SSD 9752870

160 Oxford Street, Paddington

Submission in Objection - Oxford160 Mixed-Use Development

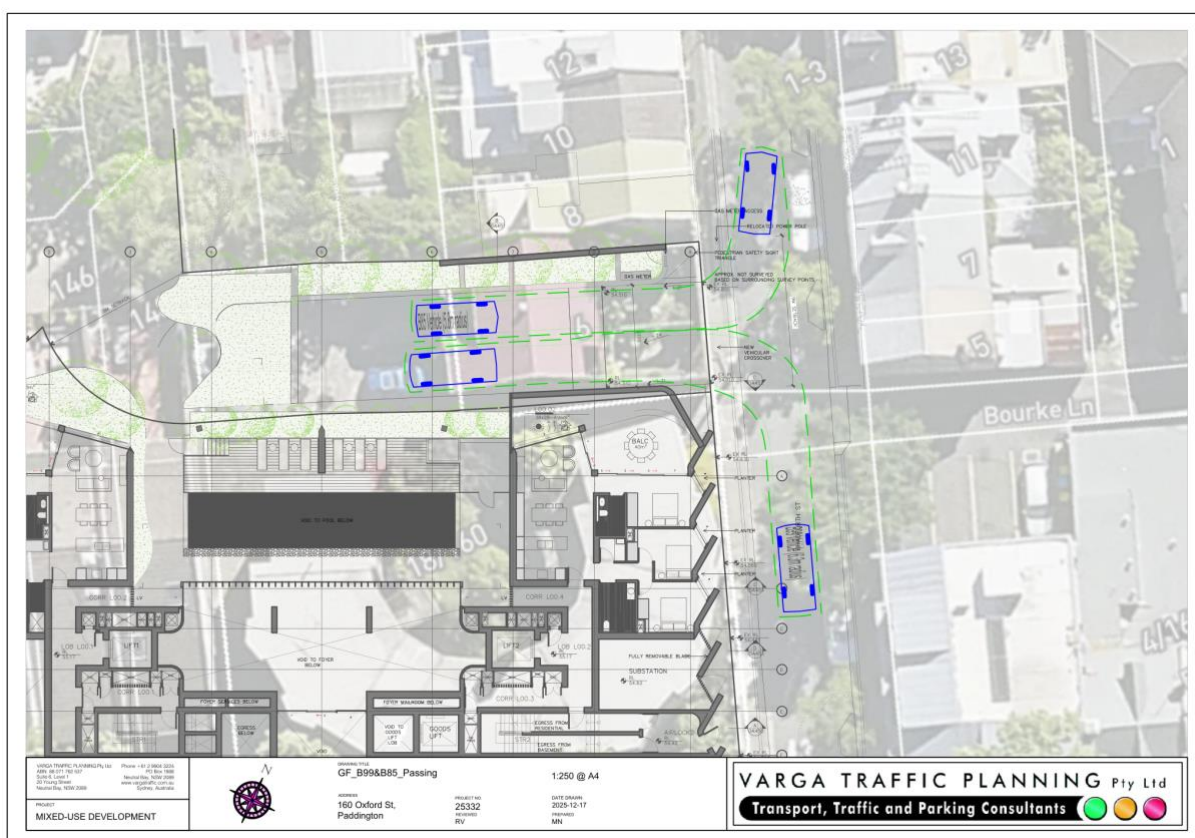
The swept path analysis in the Transport Assessment (Varga, drawing GF_B99&B85_Passing) shows a B85 design vehicle with a 5.8m turning radius turning left from the basement exit onto Shadforth Street. The swept path arc makes contact with the kerbside parking on the eastern side of the street. The Transport Assessment's narrative conclusion that vehicles can manoeuvre without impact is directly contradicted by the consultant's own diagram. The proposed development therefore does not achieve the outcome required by DCP C1(b) - a departure established on the developer's own evidence - this impact has not been adequately assessed in the EIS.

Figure GF_B99&B85_Passing (Source: Varga Traffic Planning, Transport and Accessibility Impact Assessment, November 2025): B85 vehicle (5.8m turning radius) and B99 vehicle (6.3m turning radius) exit swept paths at ground floor level. The B85 swept path arc makes contact with the kerbside parking space on the eastern side of Shadforth Street. The Transport Assessment's text does not acknowledge this impact on on-street parking.

The swept path analysis confirms that vehicle turning movements on exit from the basement make contact with the kerbside parking on Shadforth Street. Additionally, the new vehicle crossover will require no-stopping zones on either side, permanently removing kerbside spaces that existing residents, who have no off-street parking alternatives, currently depend upon. The proposed development therefore does not achieve the outcome required by DCP C1(i), and this impact has not been assessed in the EIS.
